MEMORANDUM

TO: Jean Fraser
FROM: David Senus, P.E., Lauren Swett, P.E.
DATE: April 19, 2011
RE: Harborview Townhouses, Level III Preliminary Site Plan Application

Woodard & Curran has reviewed the Preliminary Level III Site Plan Application for new Harborview Townhouses located at 127-129 York Street in Portland, Maine. The proposed project includes the construction of a new 4,160 square foot building to house seven new residential units on an urban infill lot.

DRAWING NO.
C-2

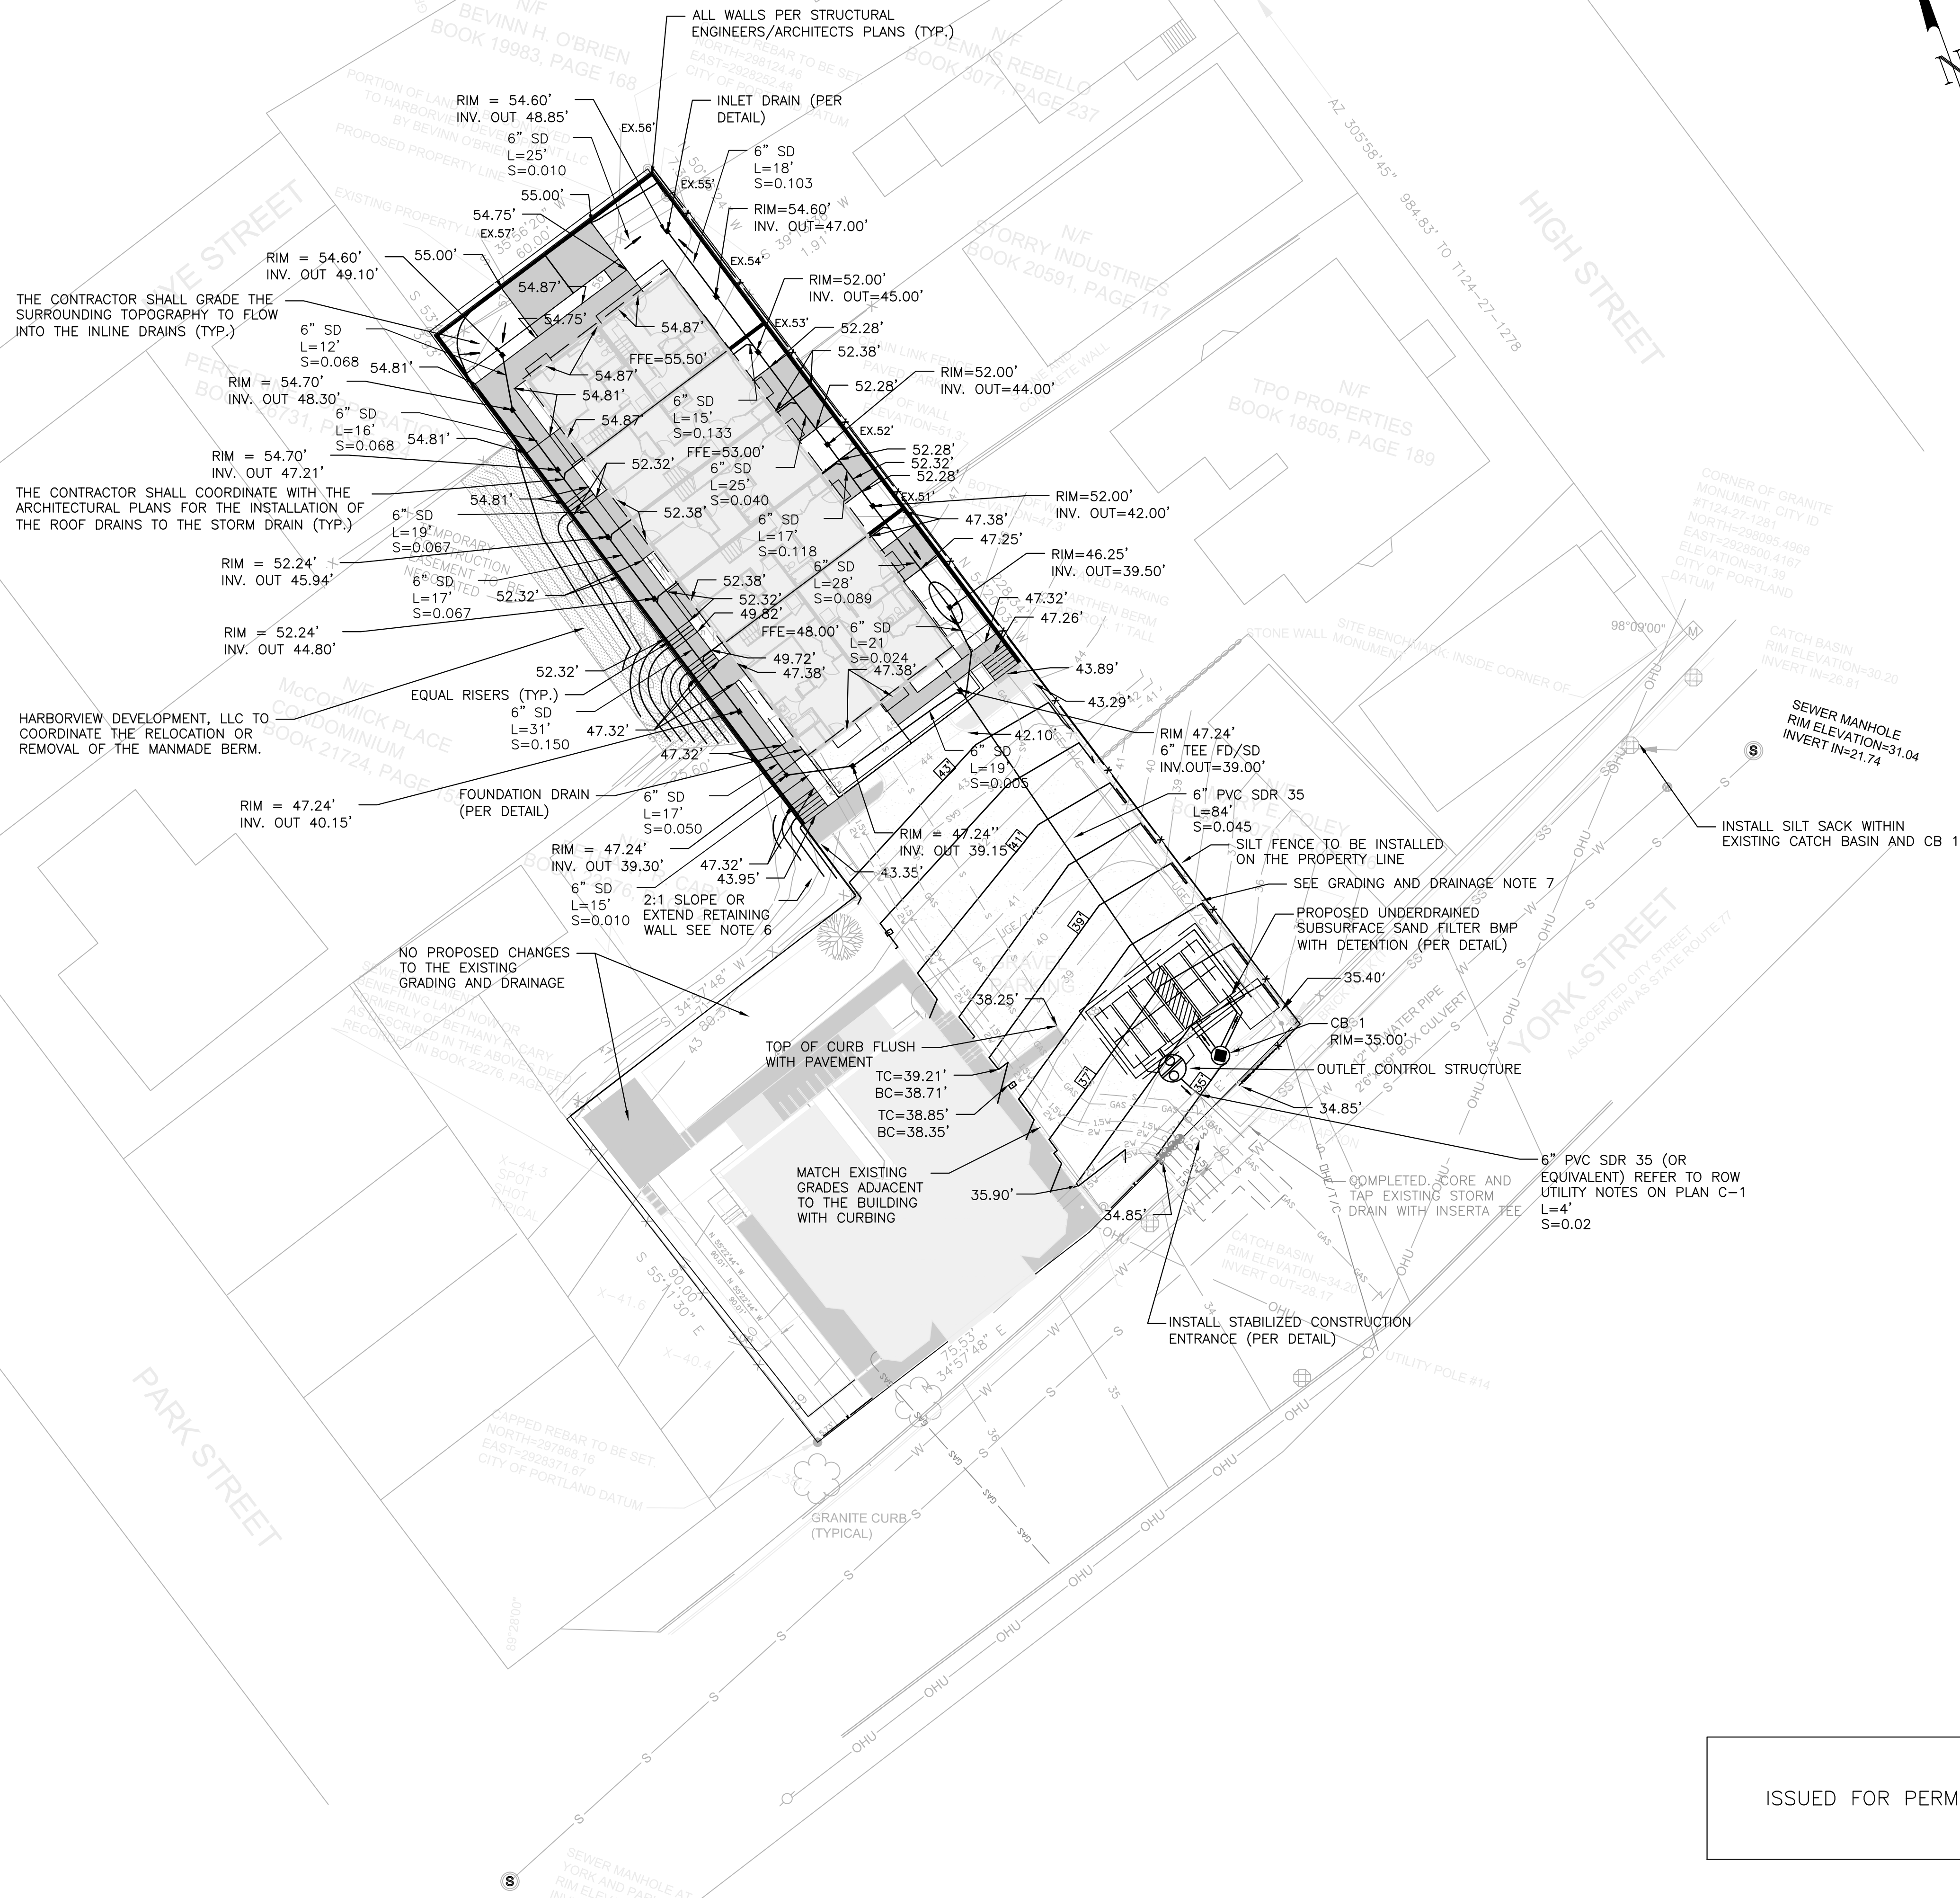
- Grading and Drainage Note 1 on Sheet C-2 states that acceptable types of stormdrain pipes include Corrugated Metal Pipe (CMP) and High Density Polyethylene Pipe (HDPE). Per Section 2.5.2 of the City of Portland Technical Manual, these are not acceptable pipe materials for work within the City of Portland Right of Way.
